Response to Submission Drawing Update Register

Revision: 2 - 28/02/2020

SSD Stage 2 - Response to Submission Drawing Update Register

Concept Modification - Response to Submission Drawing Update Register

RETAINING WALL SCHEDULE			
WALL REFERENCE	ORIGINAL SSD1 WALL REFERENCE	APPROX. LENGTH	PROBABLE MAX HEIGHT
RW01	RW04	*	*
RW02	RW01	250m	3.4m
RW03	RW02	60m	1.5m
RW04	RW02	124m	3.4m
RW05	RW06	67m	2.2m
RW06	RW03	48m	3.0m
RW07	N/A	25m	1.6m
RW08	RW06	28m	3.4m
RW09	N/A	40m	2.5m

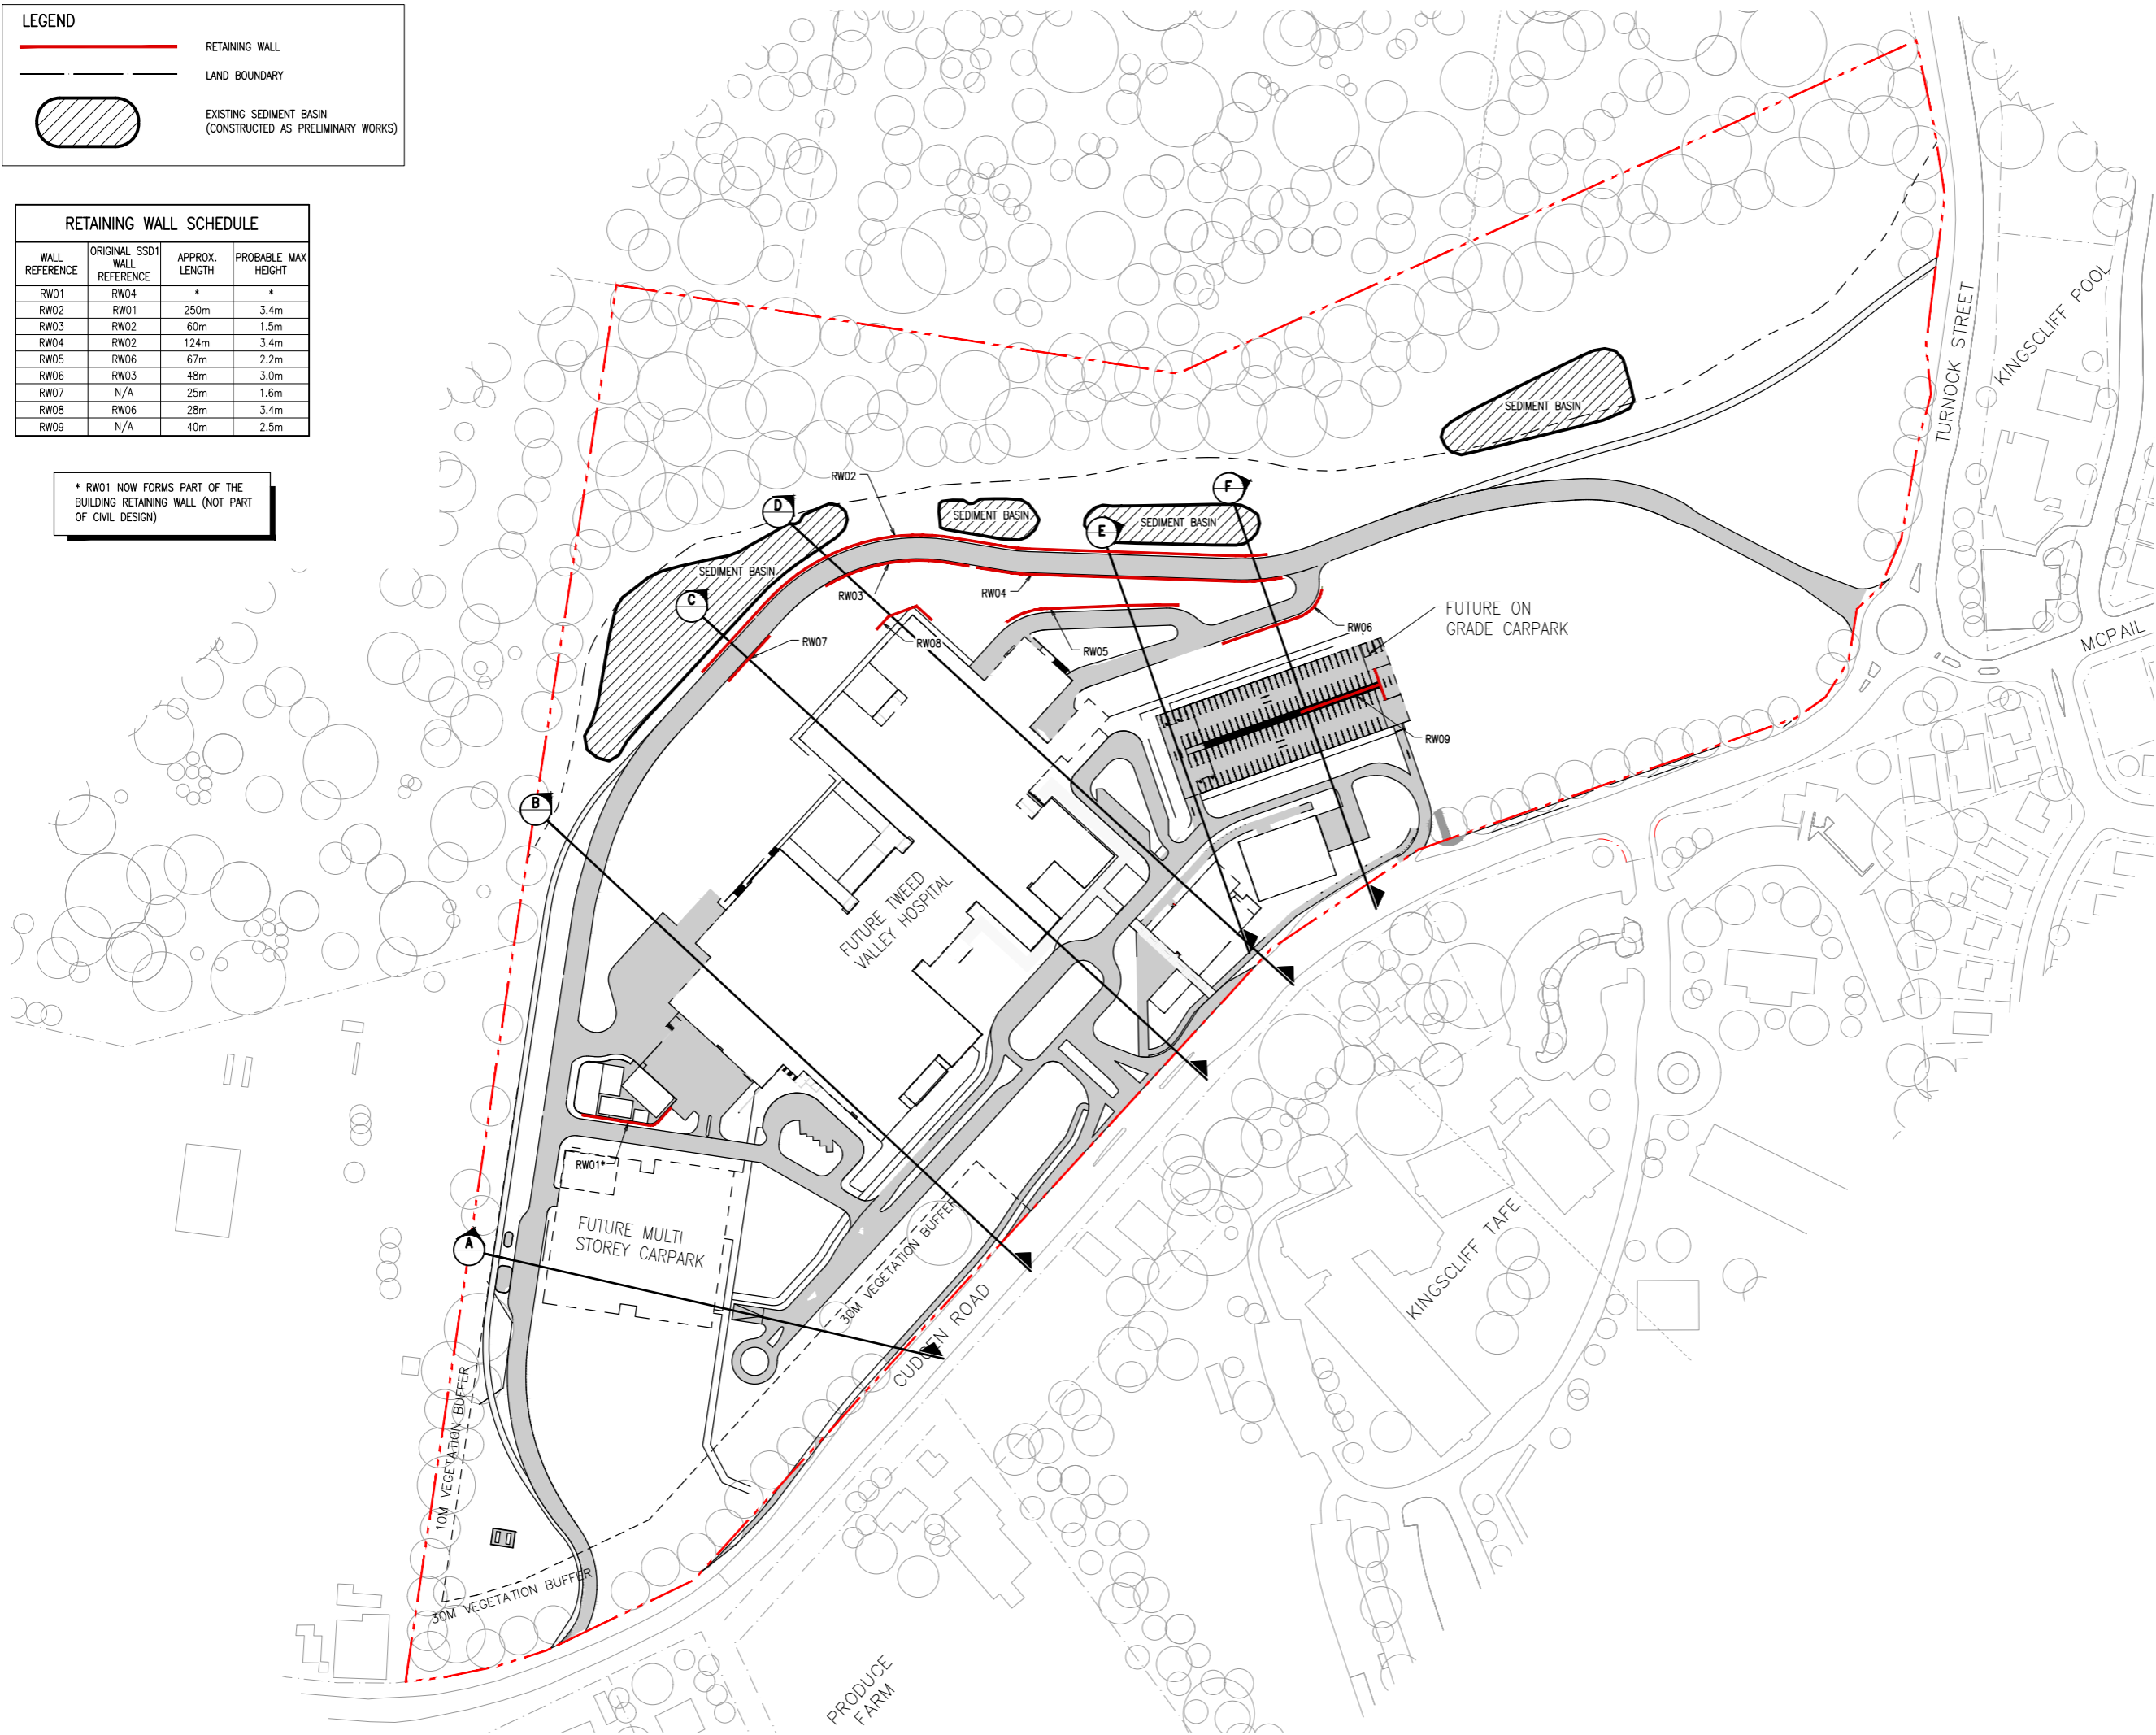
Drawing Name	Drawing No.	Submission Pack	Page	Revision	Issue	Changed (Y/N)	Description of Change
STAGE 1 EARLY AND ENABLING WORKS CONSTRUCTION RETAINING WALL PLAN	C-10-101	-		7	ISSUED FOR SSSA	Y	NEW RETAINING WALL LOCATION
STAGE 1 EARLY AND ENABLING WORKS CONSTRUCTION CUT AND FILL PLAN	RBG-CV-DWG-RIE-82-701	-		1	ISSUED FOR SSSA	Y	NEW CUT AND FILL QUANTATIES
STAGE 1 EARLY AND ENABLING WORKS CONSTRUCTION LONGITUDINAL SECTION - SHEET 1 OF 2	RBG-CV-DWG-RIE-82-721	-		1	ISSUED FOR SSSA	Y	NEW CUT AND FILL SECTIONS
STAGE 1 EARLY AND ENABLING WORKS CONSTRUCTION LONGITUDINAL SECTION - SHEET 2 OF 2	RBG-CV-DWG-RIE-82-722	-		1	ISSUED FOR SSSA	Y	NEW CUT AND FILL SECTIONS
